From: Joanne Lewis <Joanne.Lewis@arun.gov.uk>
Sent: 24 June 2020 16:37
To: Planning.Responses <Planning.Responses@arun.gov.uk>
Subject: RE: Planning Consultation on: A/76/20/PL

Application No: A/76/20/PL

Site Address: Land at Dapers Lane Angmering

Description of Works: 84 No. dwellings, public open space, play areas, associated infrastructure & landscaping. This application affects a Right of Way.

Parking Strategy Plan

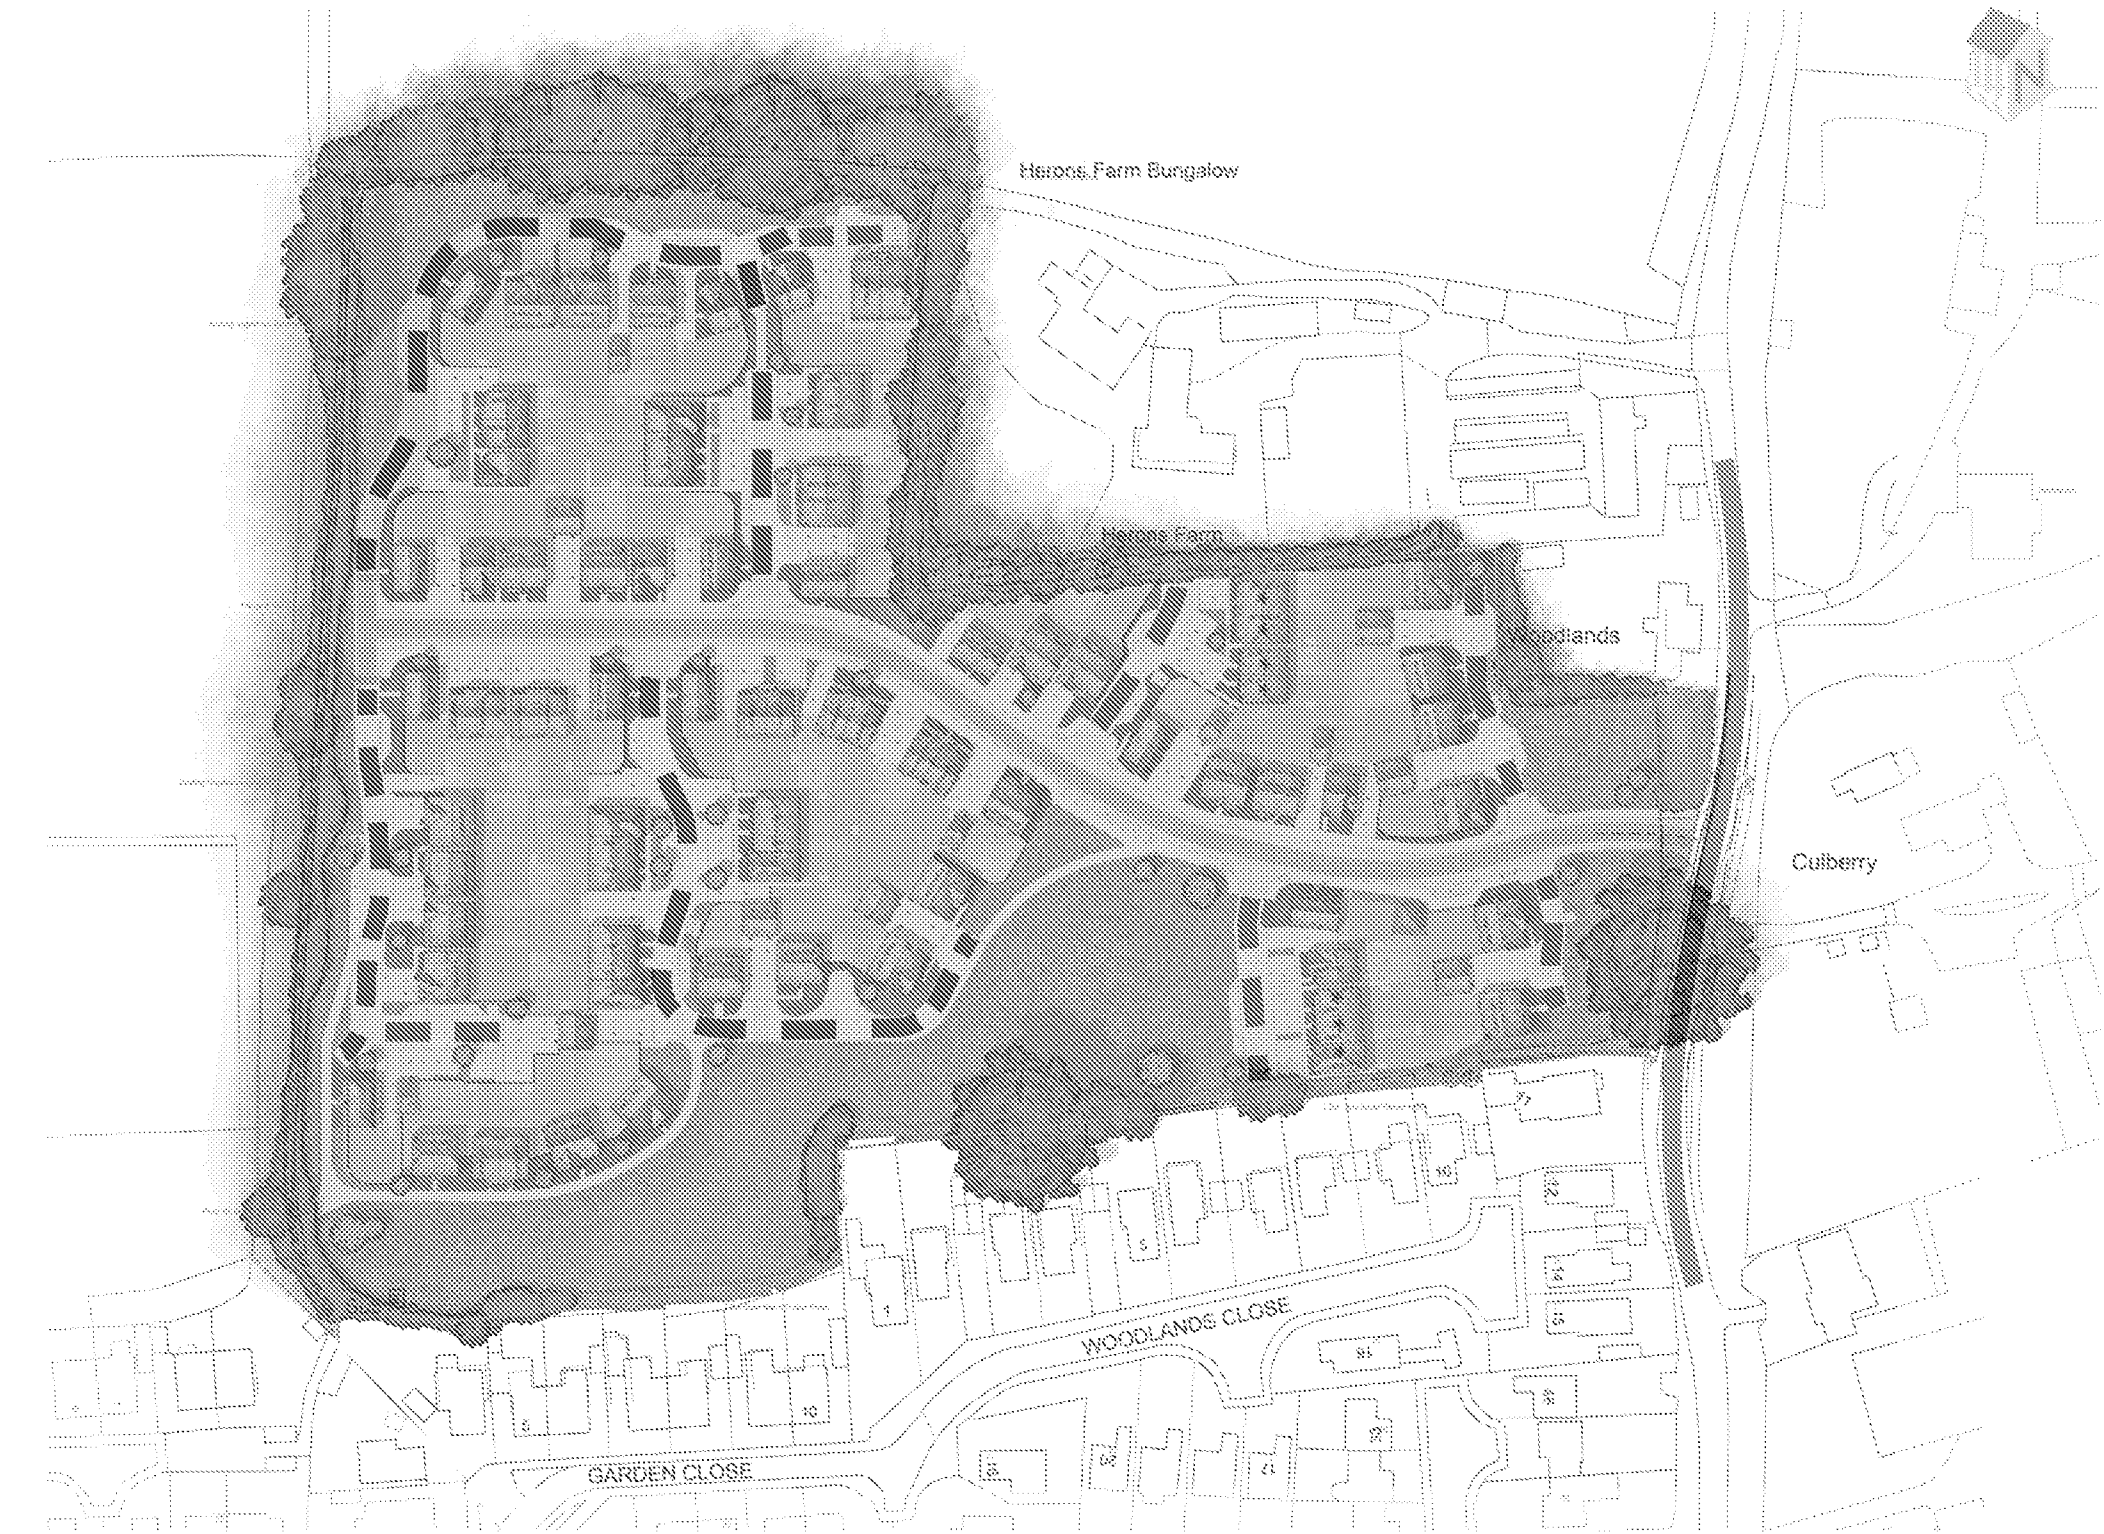
The design and access statement for this development states in Section 6.17 that 27 dwellings will have active EV points and 23 charging points allocated to private dwellings across the site (20% of 114 spaces). This amount is not sufficient, the ADC Vehicle Infrastructure Study sets out that all houses with a garage OR driveway should have a charge point. It appears from the plans that most if not all properties on the development have either a garage or driveway/allocated space and so all these properties should have an electric vehicle charge point. It is also noted that none of the properties allocated as social housing have a charge point according to the submitted plan. It is recognized that the cheapest way to charge an electric vehicle is at home over night. Failing to provide the social housing properties with an EV point is disadvantaging those who could potentially benefit the most from the savings from reduced petrol/diesel costs that owning and being able to charge an electric vehicle would provide.

I would therefore recommend that the developer re thinks the number of charge points to be installed in line with the above information or the following condition is included on any permission granted;

- Prior to occupation of any of the dwellings, a scheme for the provision of facilities to enable the charging of electric vehicles to serve the approved dwellings shall be submitted to the local planning authority for approval and thereafter implemented in accordance with the approved details and the charge points shall thereafter be retained and maintained in good working condition.
